## OXFORDSHIRE COUNTY COUNCIL'S RESPONSE TO CONSULTATION ON THE FOLLOWING DEVELOPMENT PROPOSAL

**Application no:** 23/03438/REM

**Proposal:** Reserved Matters application to 23/01941/F requesting consideration of layout, scale, appearance and landscaping.

**Location:** The Innovation Quarter, Bicester Heritage, Buckingham Road, Bicester

PARKING /ARRIVAL STRATEGY

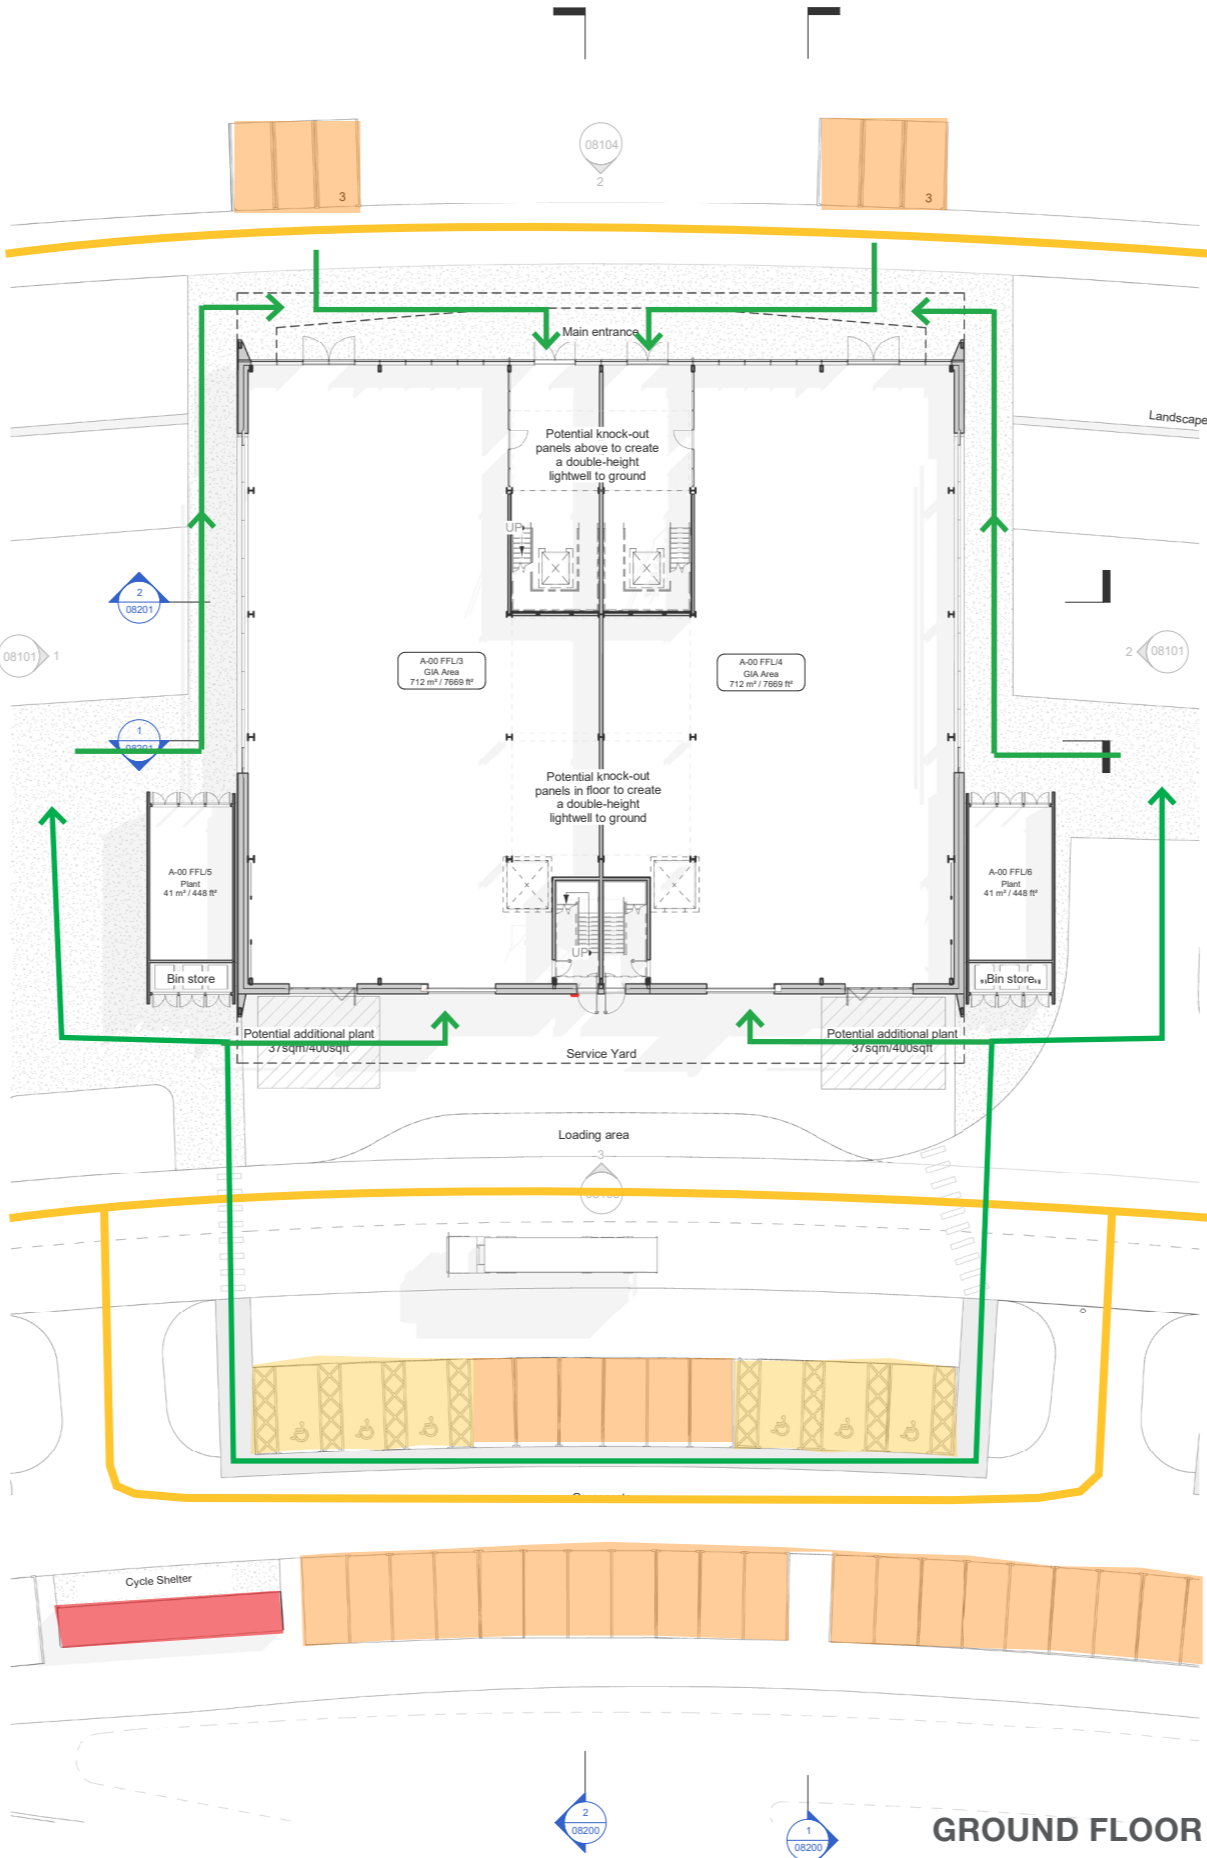
An objection is also raised on the design of cycle parking. The site currently feels dominated by car parking with cycle parking pushed into the corner as far from the building as possible. This is the wrong way round – in order to make cycle as attractive as possible it is important that cycle parking is prioritised, not added as an after-thought. The cycle parking should be as close to the building as possible for convenience and so it is overlooked to make users feel more secure. I would suggest at the very least relocating the cycle parking closer to the buildings and moving some of the car parking back.

The county council does also not support the use of double-stacked cycle parking as stated within the Parking Standards for New Developments document. These are difficult to use for a large number of users and are therefore often underutilised, a small portion may be provided but the Local Highway Authority would like to see the majority of spaces as covered Sheffield stands with a minimum of 1m spacing (ideally 1.2m as stated within LTN 1/20). Additional wider spaces should be provided for users with reduced mobility along with cargo bikes and trailers which are becoming increasingly popular.

I would like to see further information regarding the pedestrian and cycle routes throughout the site and in particular the walking routes from the car and cycle parking. These should be a minimum of 2m and should be delineated to make vehicles aware of their presence.

PHASE I PARKING

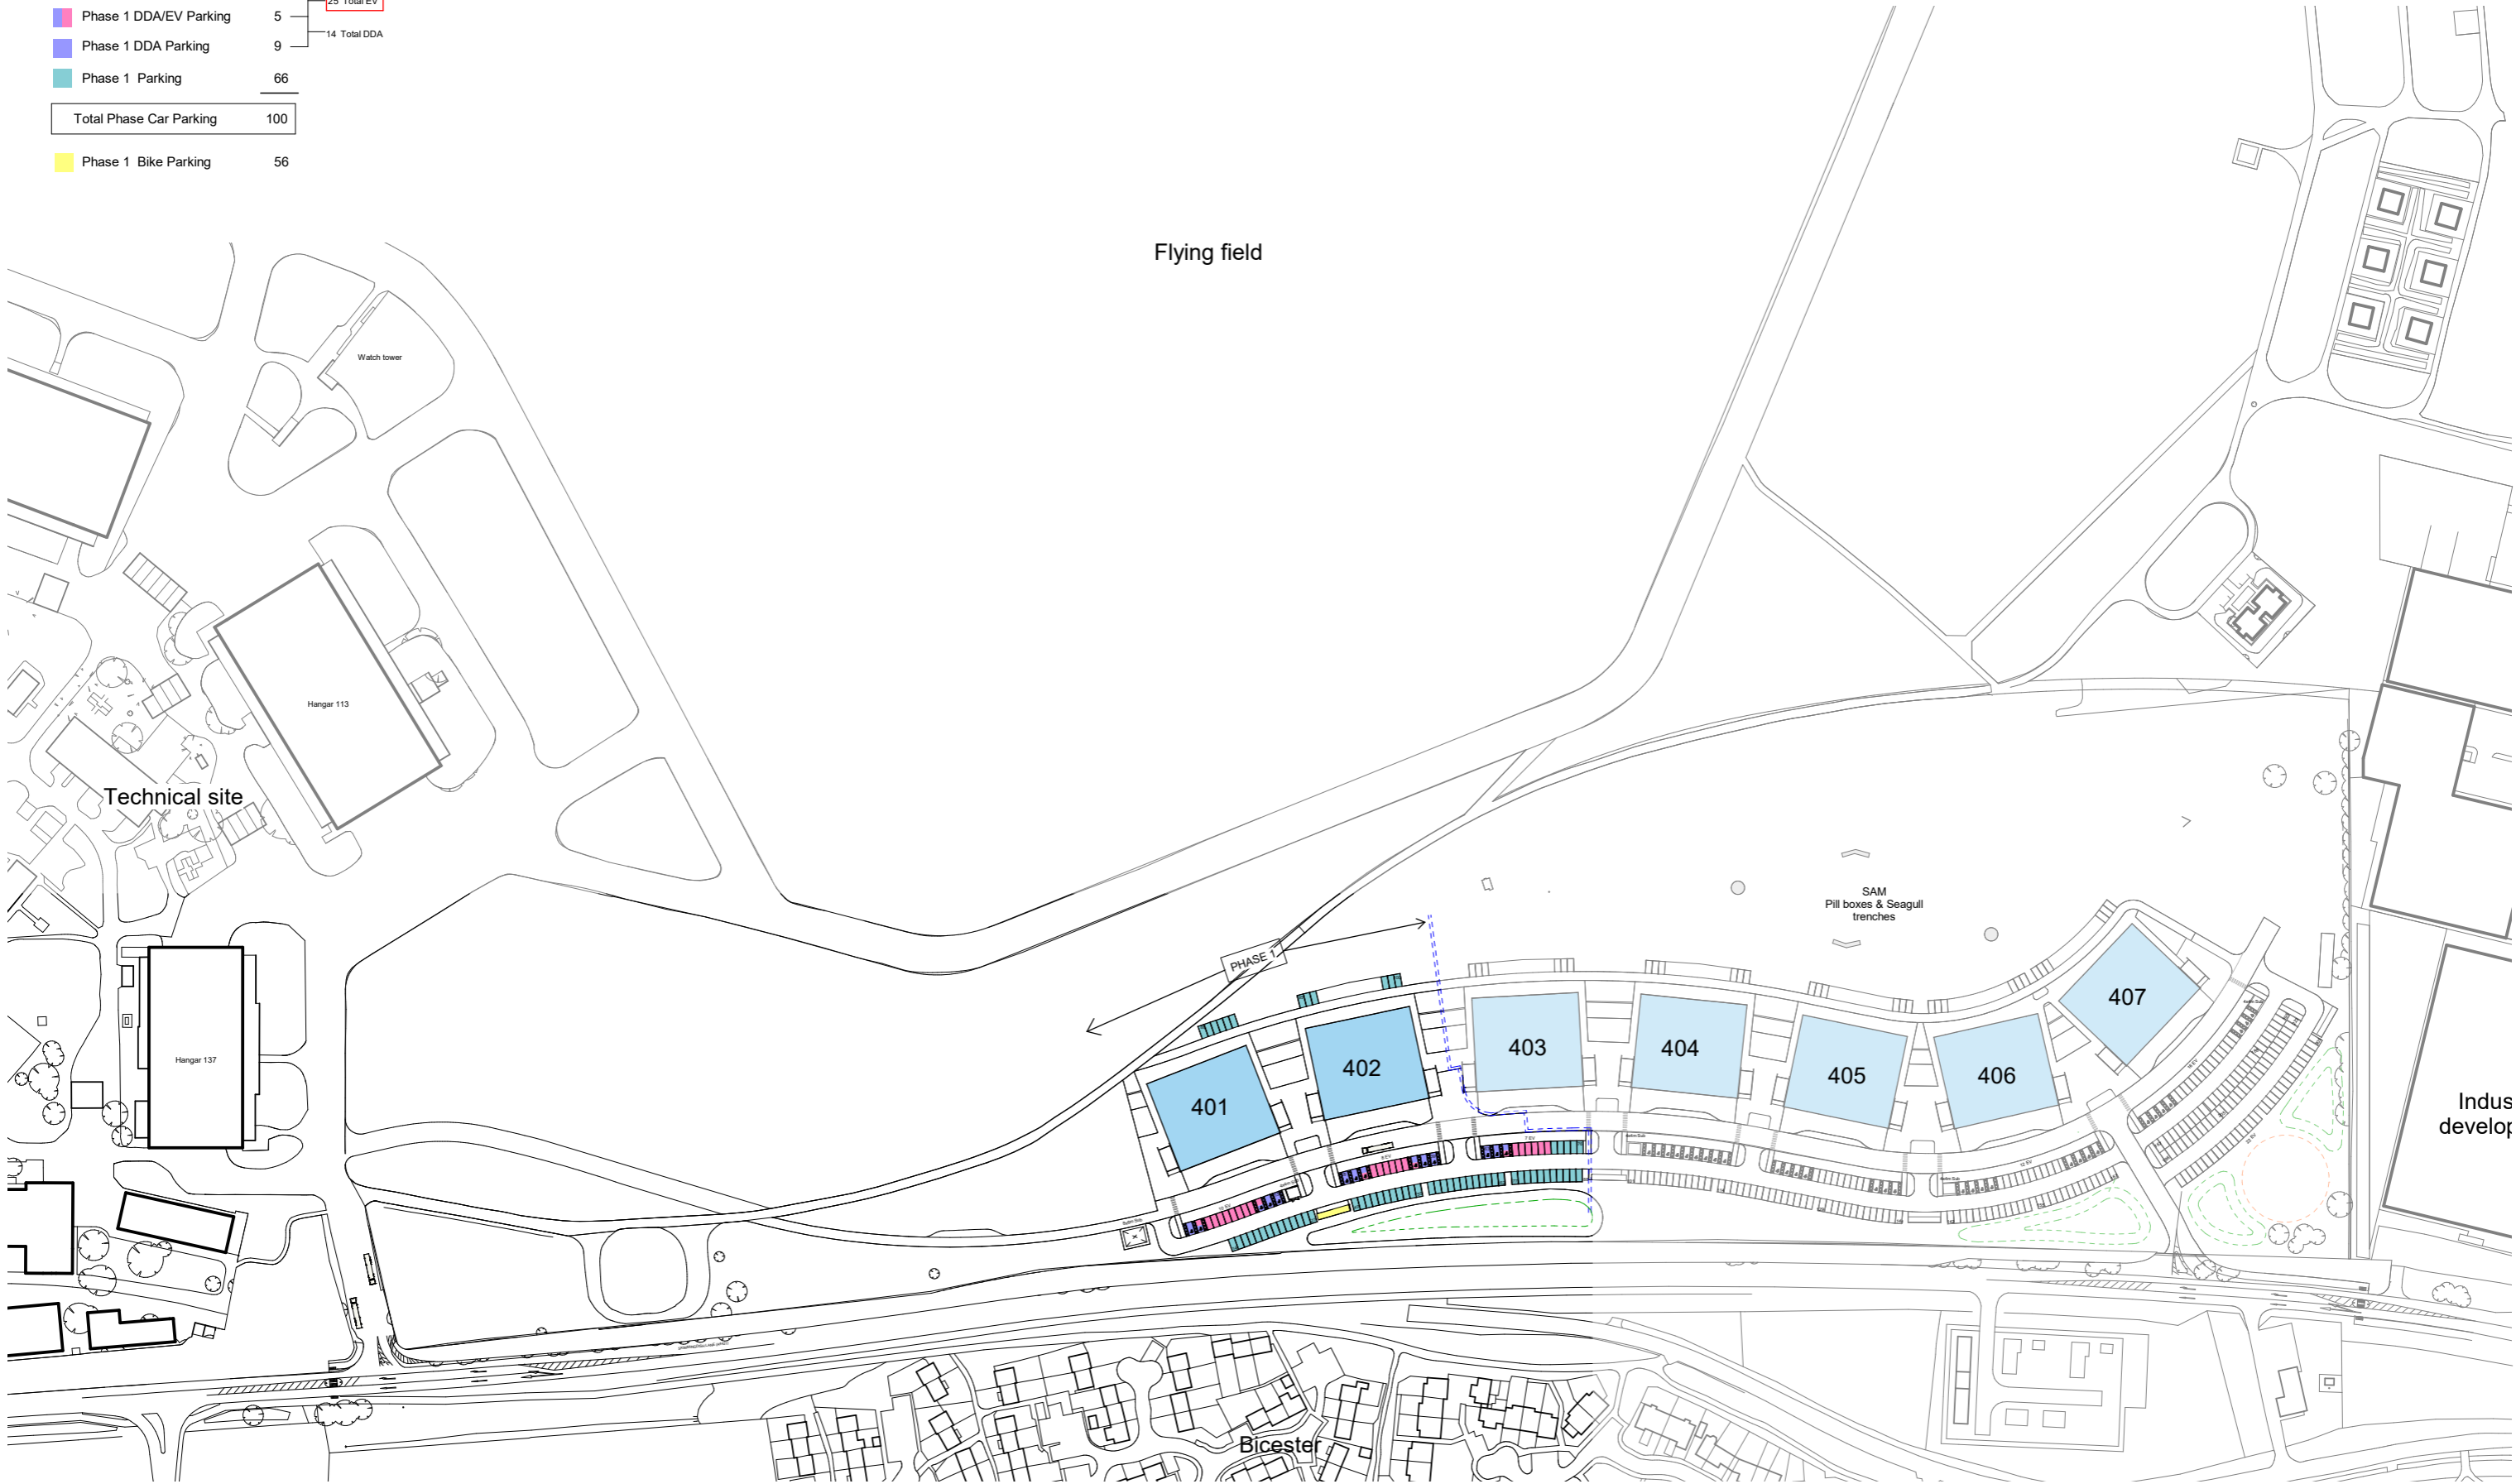
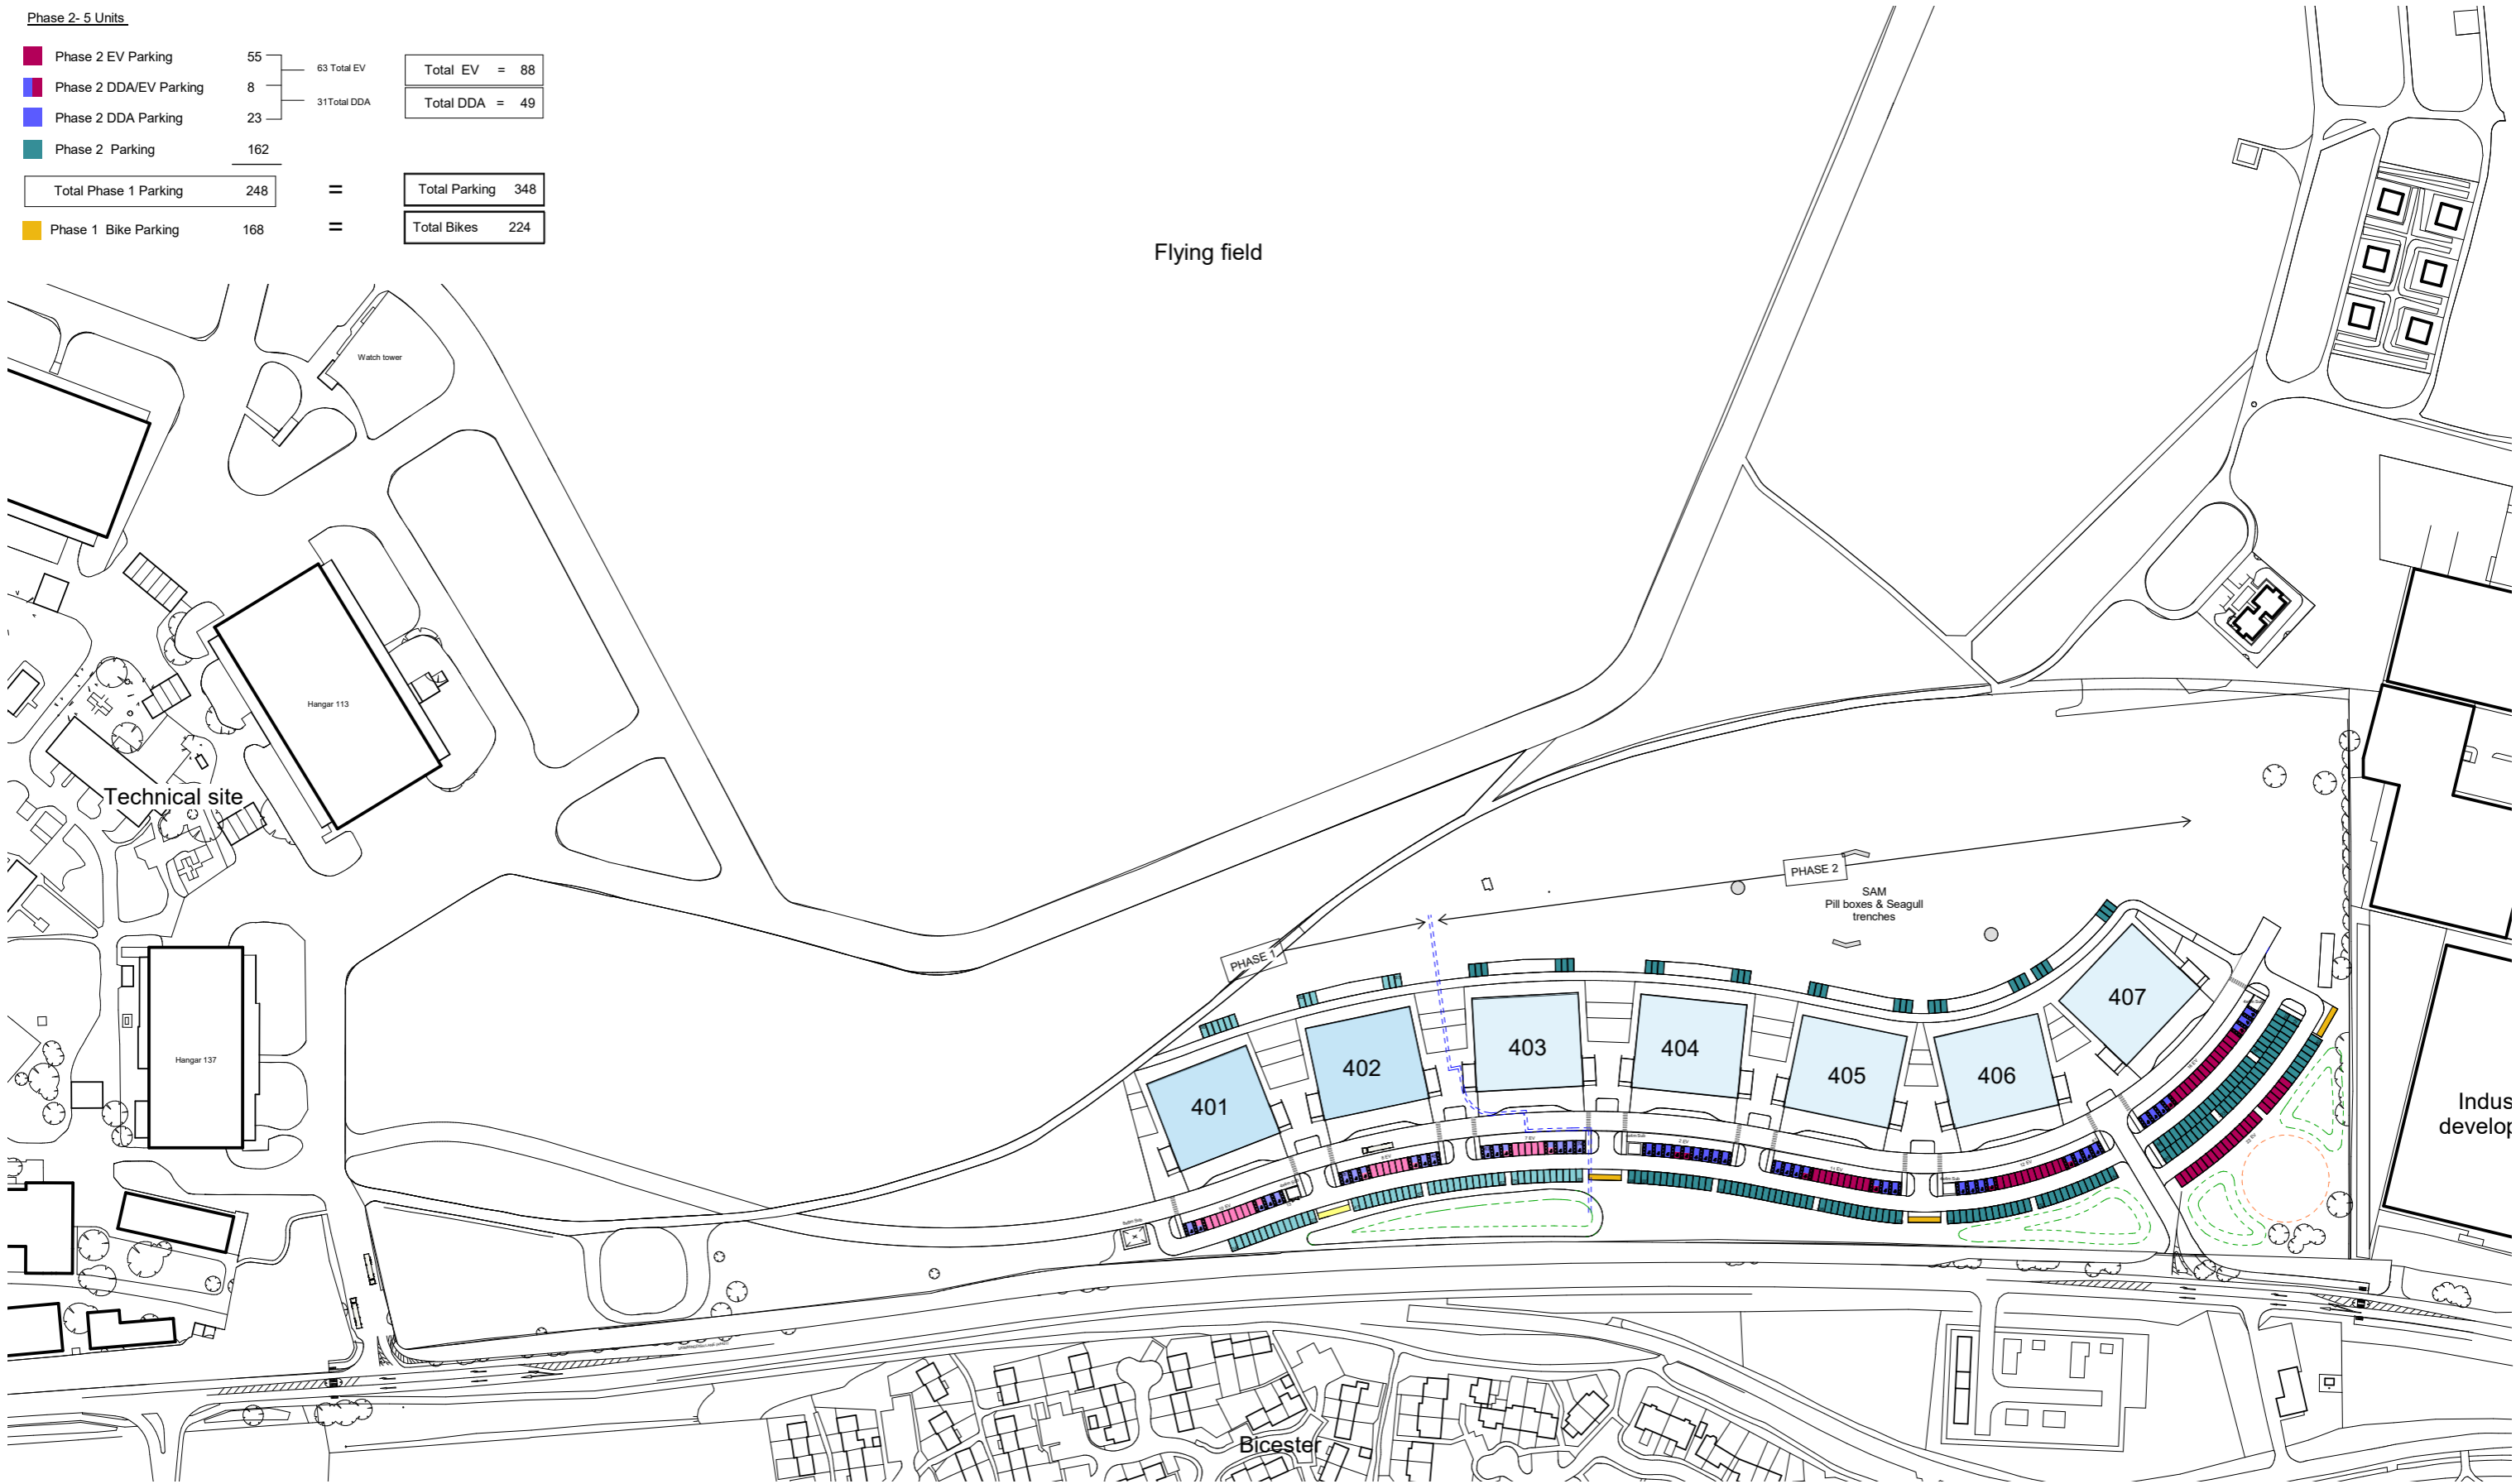
No detail has been given on the breakdown of uses and their floor areas, this makes it difficult to assess whether what is currently proposed meets the standards within Oxfordshire's Parking Standards for New Developments. Further information should be provided on this point.
